Engineering Review
 03/11/2021 2:18:44 PM
 dsdrice
 JeffRice@elpasoco.com
 (719) 520-7877
 EPC Planning & Community
 Development Department

PRELIMINARY SITE GRADING CONSTRUCTION PLANS
 FOR
SKYLINE AT LORSON RANCH

EARLY OVERLOT GRADING / EROSION CONTROL PLANS

**TYPICAL SECTION 50' R.O.W.
RESIDENTIAL URBAN LOCAL**
NOT TO SCALE

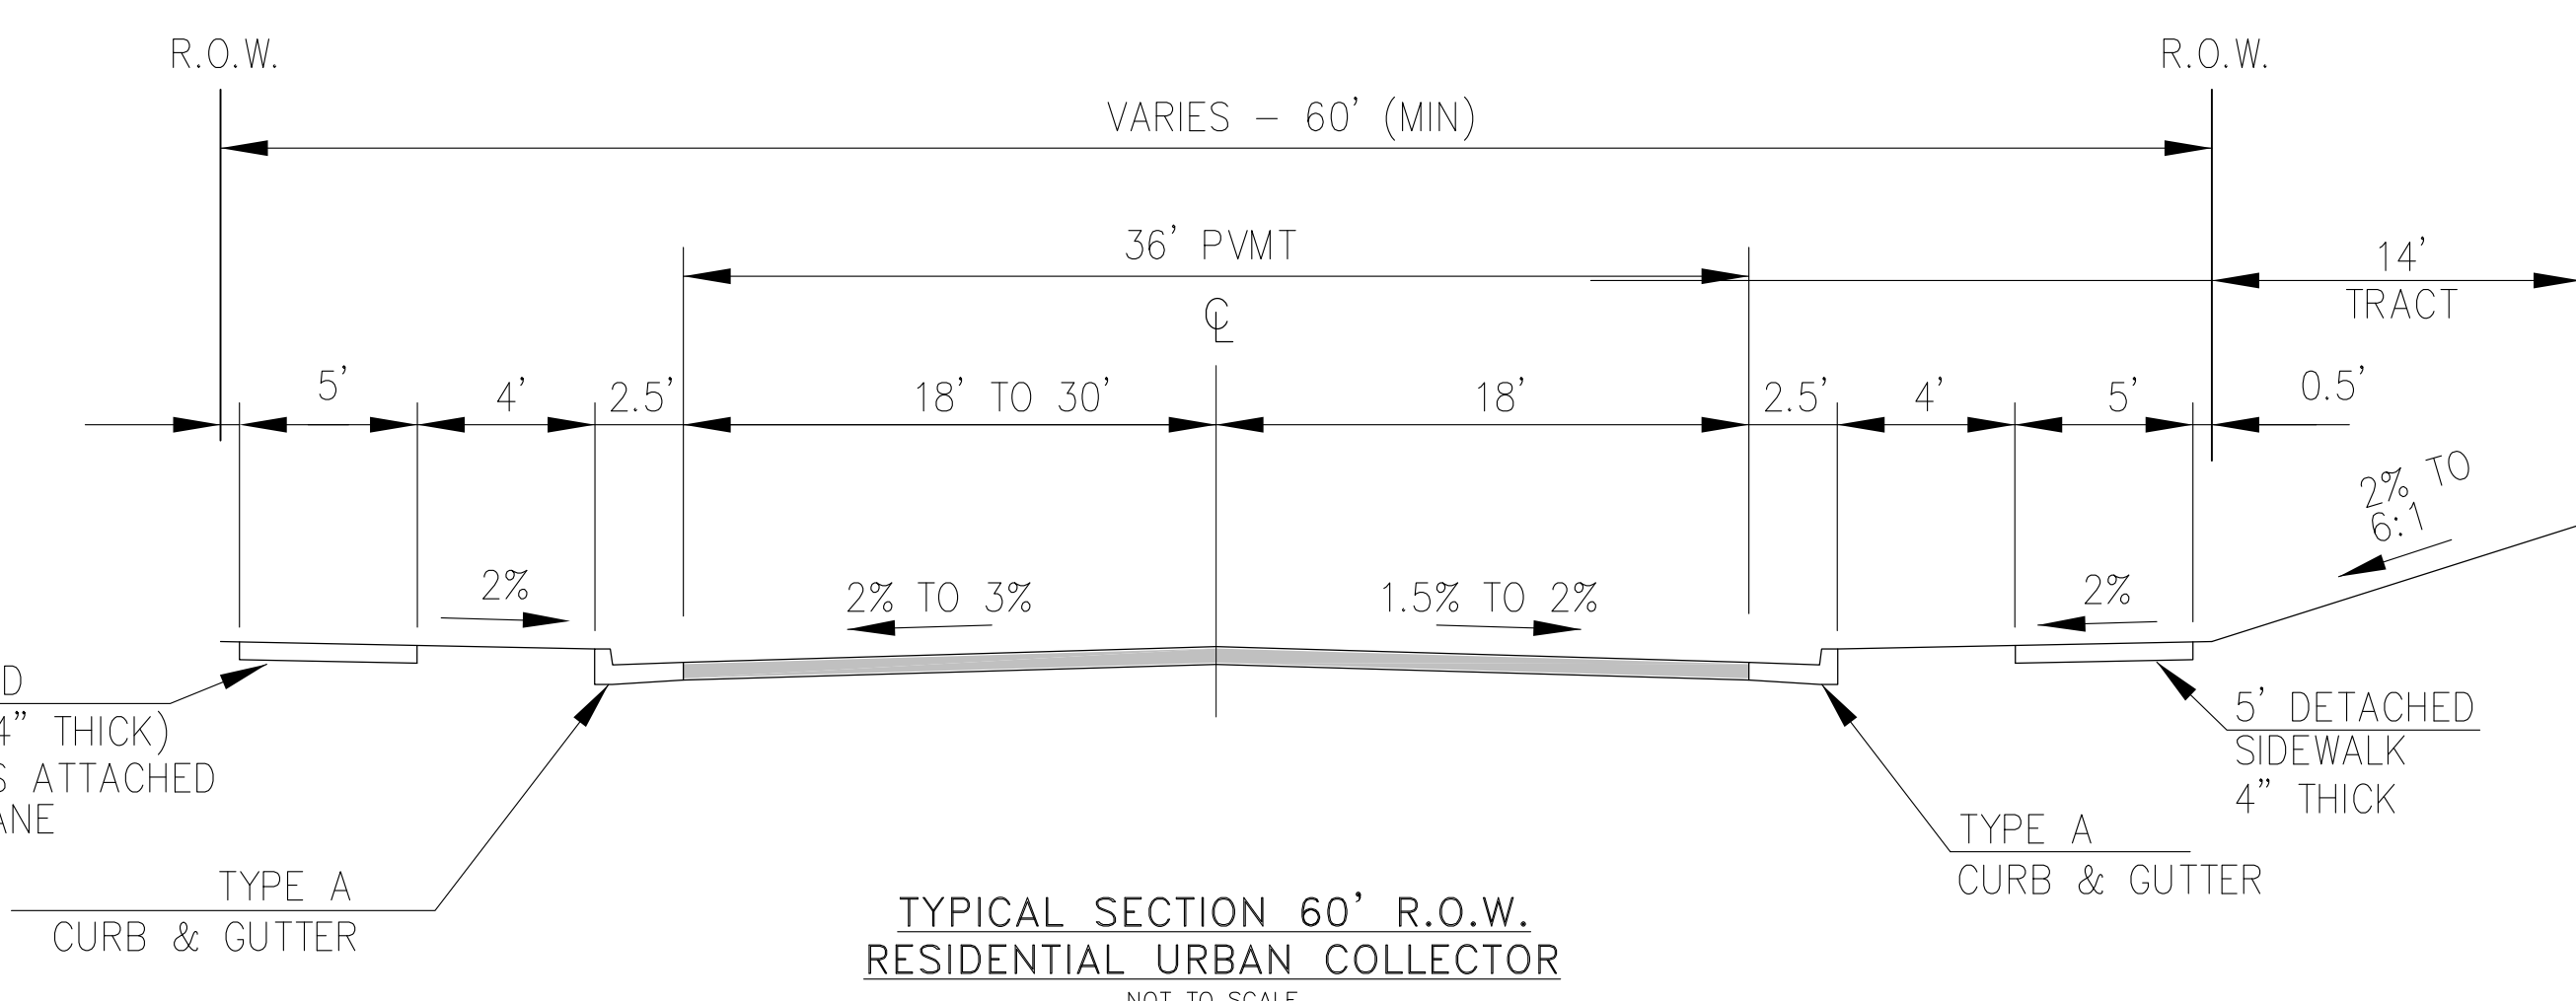
for early grading, do not show asphalt or concrete sidewalks on road detail
